TOWN AND COUNTRY PLANNING ACT 1990

FULL

Reference: H09-1285-25 **Date of Decision:** 13th February 2026
Applicant: Mr & Mrs Ringer
18 Fishpond Lane
Holbeach
Spalding
Lincolnshire
PE12 7DE
Location: 18 Fishpond Lane Holbeach Spalding
Description: Extension to existing garage to provide a ground floor games room & first floor ancillary accommodation incidental to the main dwelling

ELEVATIONS - SHEET 1
 Proposed Extension

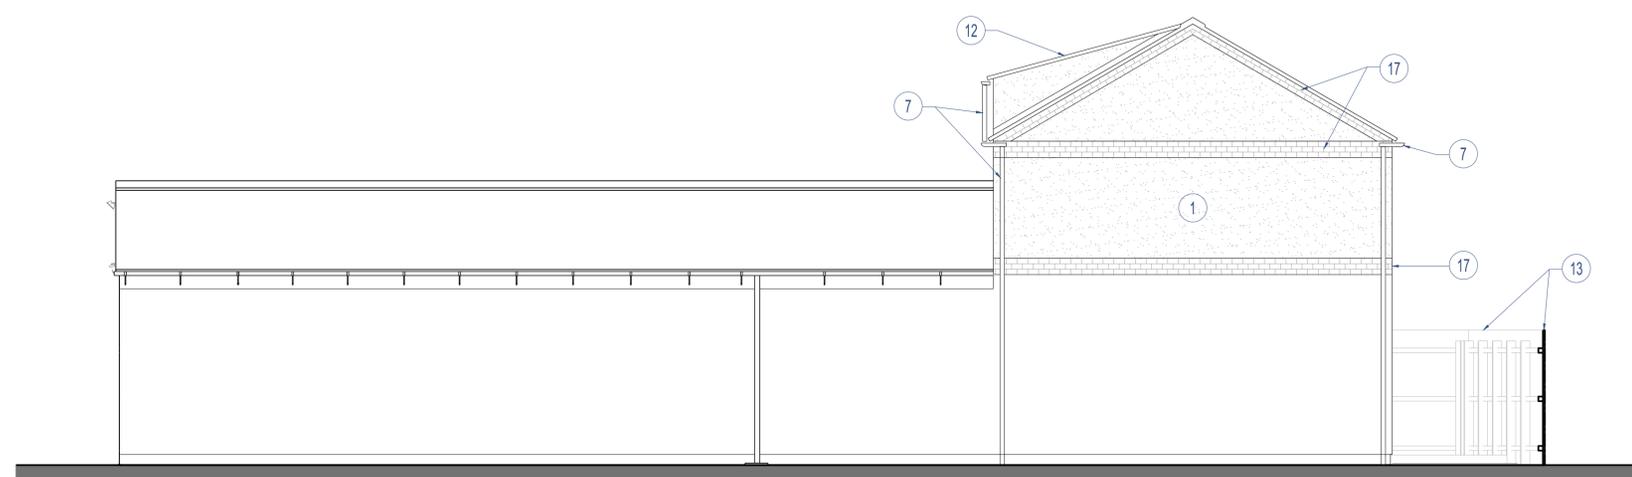
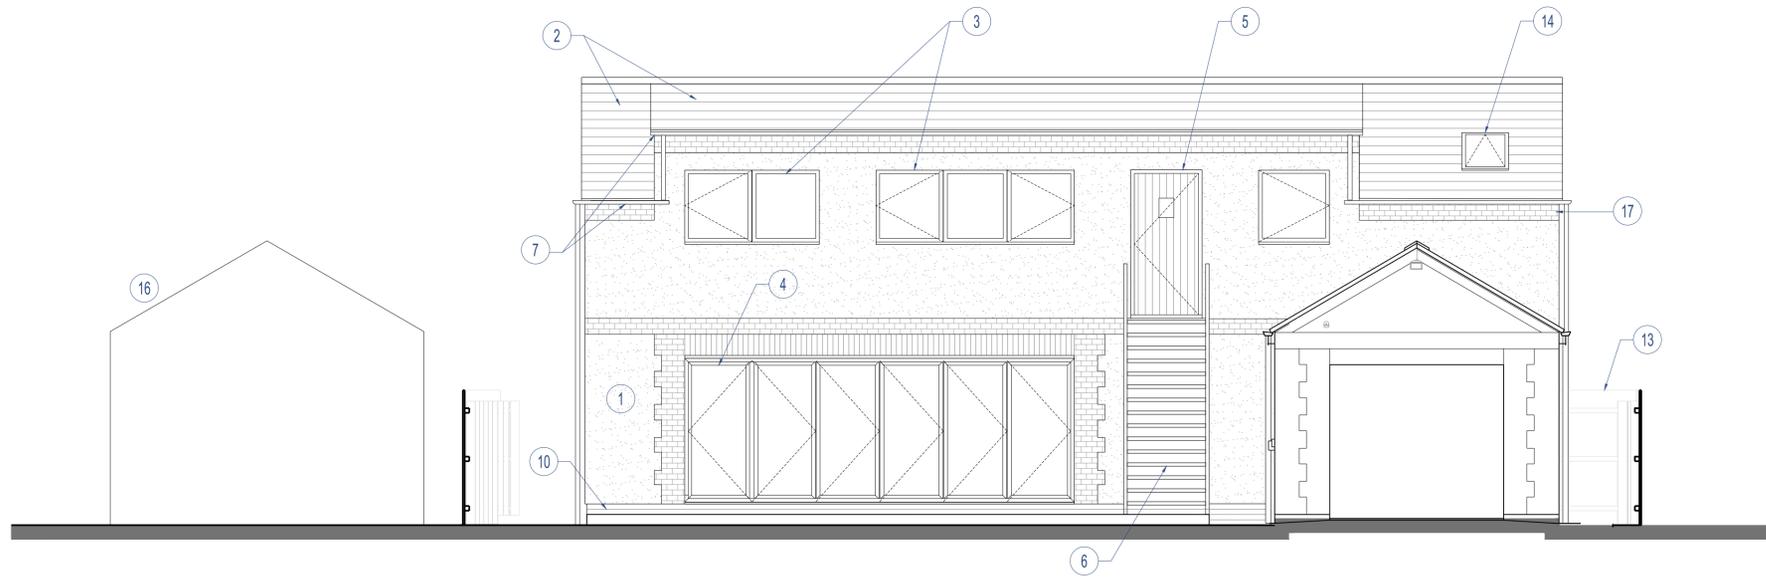
Furthermore, the disproportionate scale would also result in harm to the character and appearance of the area, through the creation of an incongruous and poorly integrated feature. The scale intrudes upon the street scene of the area, breaking the established frontage relationship.

ELEVATIONS - SHEET 2
Proposed Extension

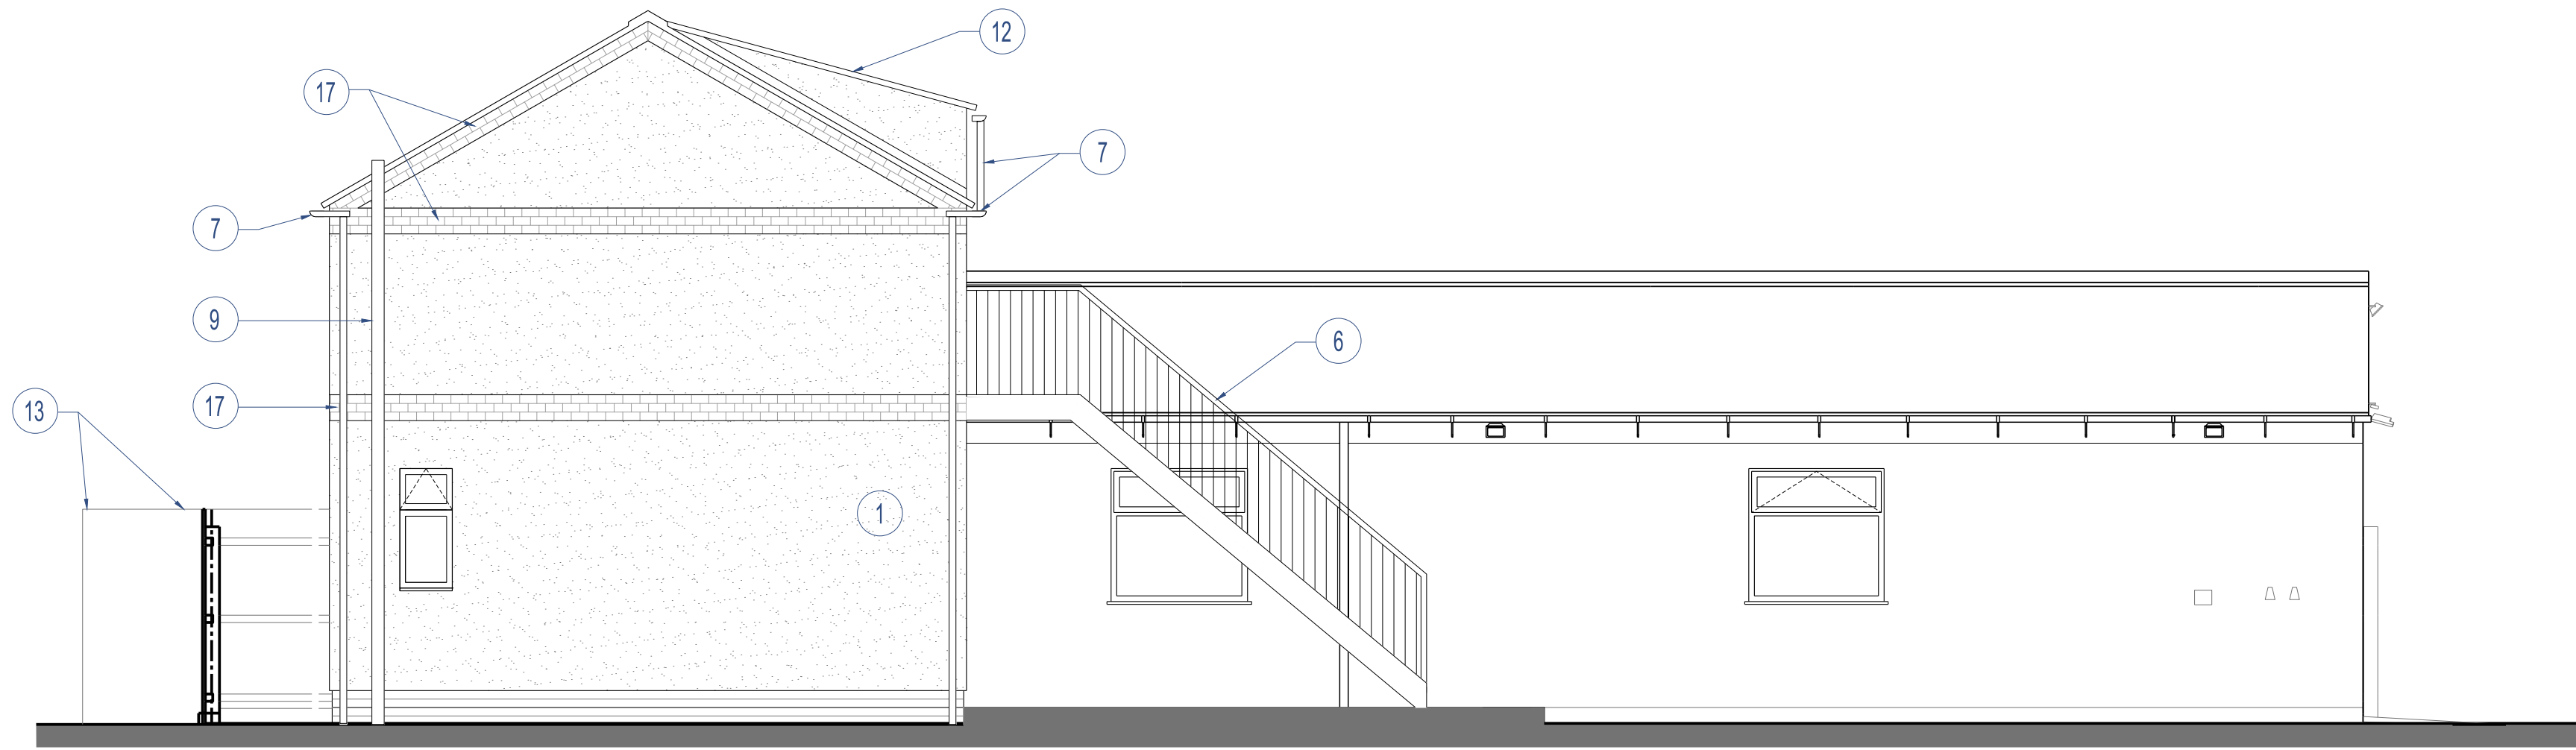
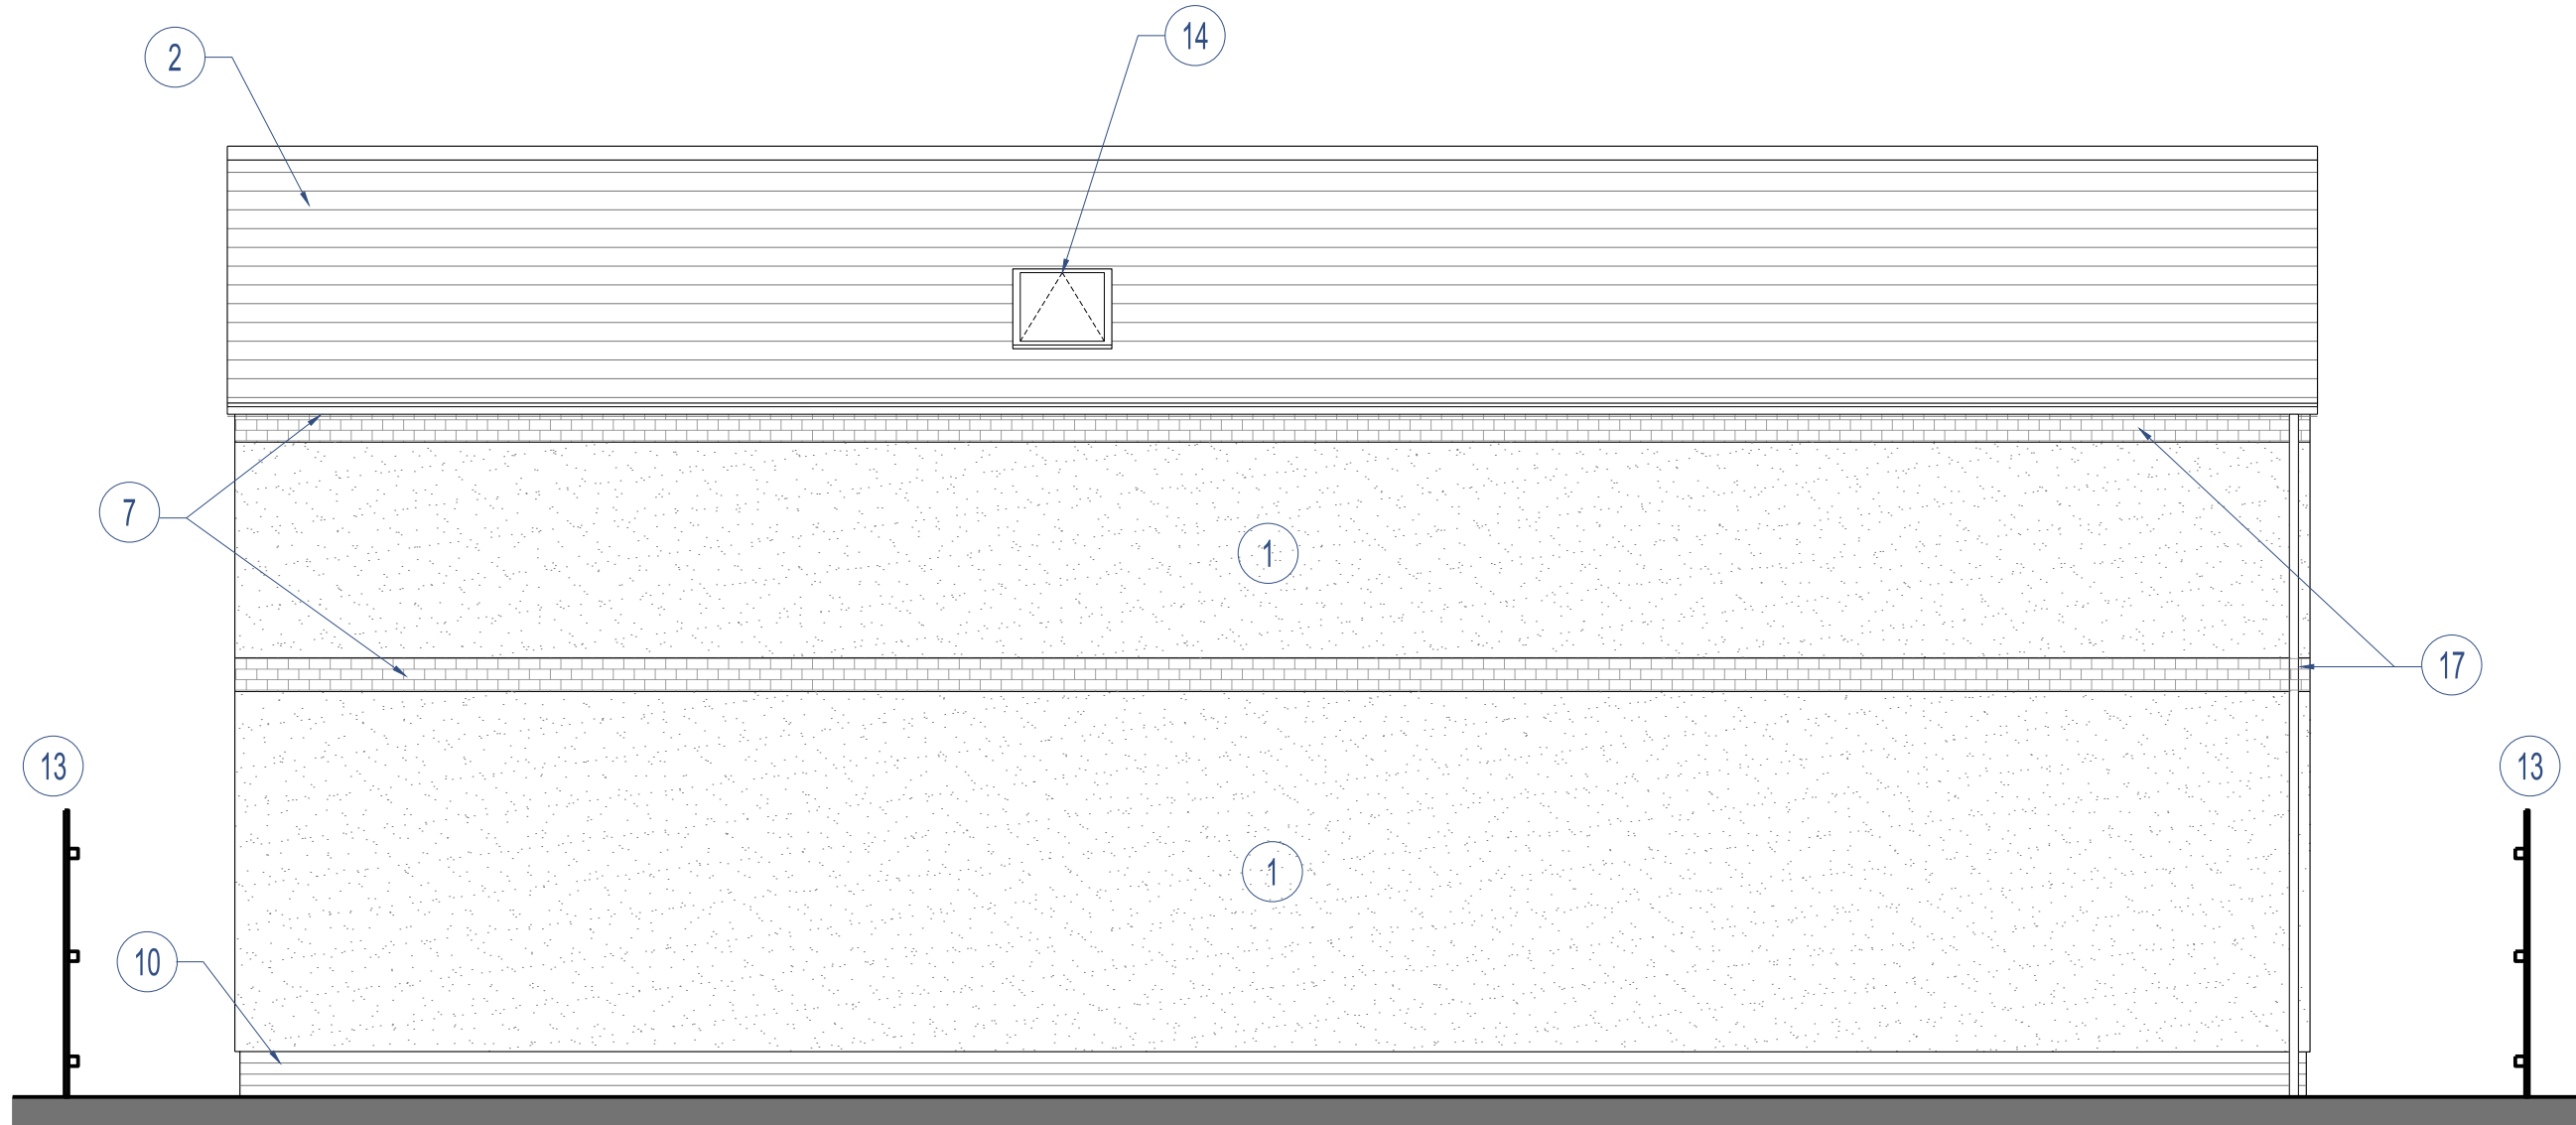
- 2 By virtue of the significant scale and the positioning of the proposal, there would be a significant and unacceptable level of impact upon the amenity of neighbouring residents. The significant scale, when combined with the proximity to the boundary of the dwelling, would result in the gardens of the dwellings to the south-west being overshadowed, thereby lessening these residents' enjoyment of their amenity space.

SITE SECTION & BLOCK PLAN
 Proposed Detailed Site Layout - Roof Level

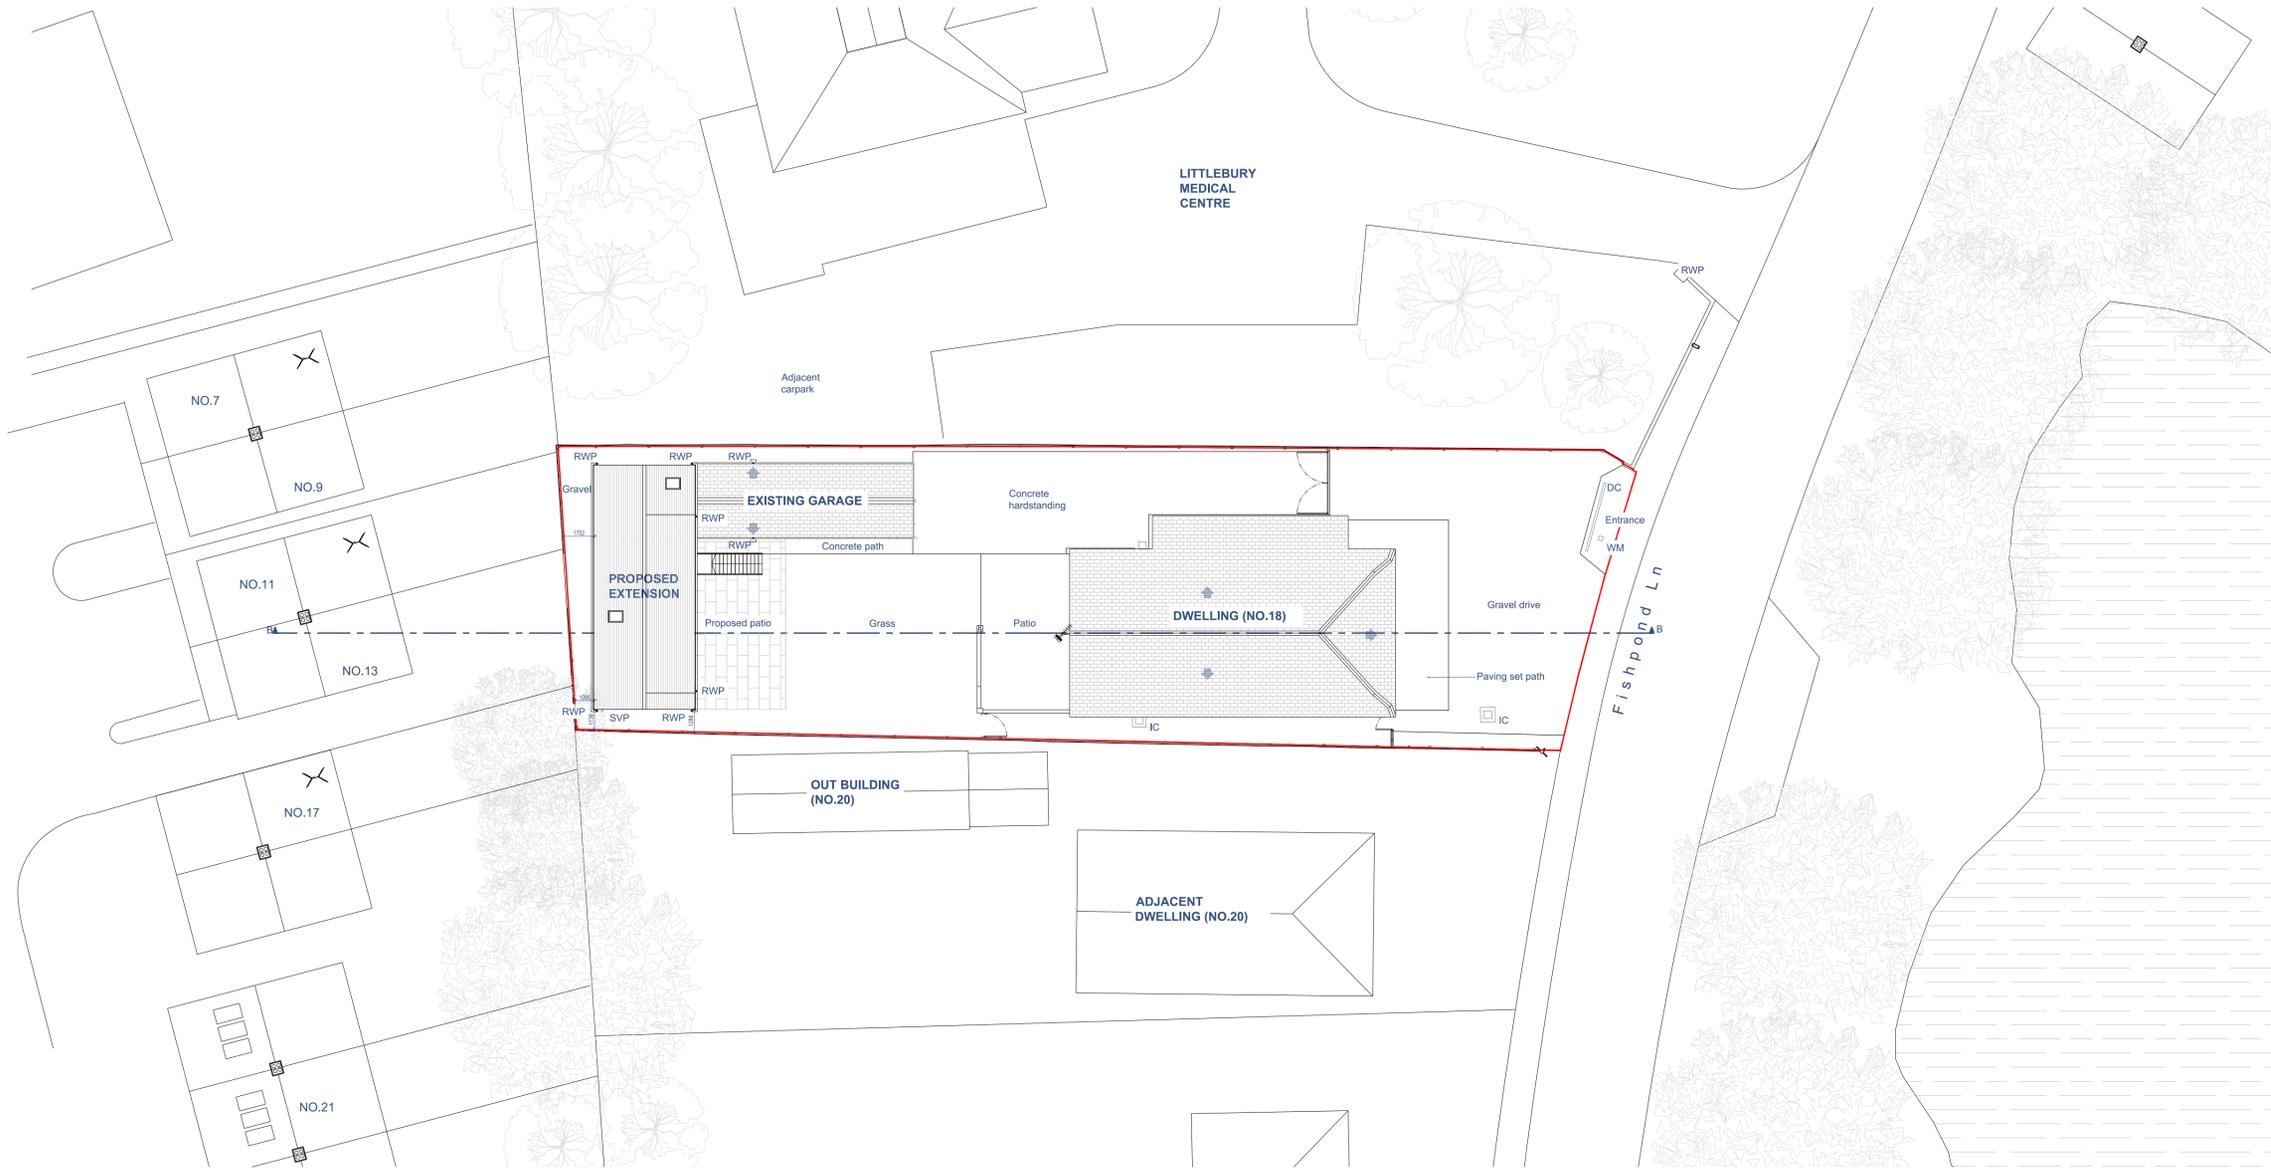
- 1 The proposal, by virtue of its significant scale relative to the existing dwelling and the relationship between the two buildings, is not considered to represent an ancillary form of development, thereby representing development tantamount to the creation of a new dwelling. The proposed annexe is of a significant size compared to the main dwelling and there would be limited reliance on the main dwelling. The positioning would enable the separation of the two buildings into distinct units. The proposed annexe is therefore not considered to be subservient or ancillary.

The proposed development would not be subservient or proportionate to the host dwelling. As such, the proposed development is therefore considered to have an

unacceptable impact upon the character of the area and is thus contrary to Policies 1, 2 and 3 of the Local Plan and Section 12 of the NPPF.

The proposal would therefore have an unacceptable impact upon residential amenity thus contrary to Policies 2 and 3 of the Local Plan and Section 12 of the NPPF.
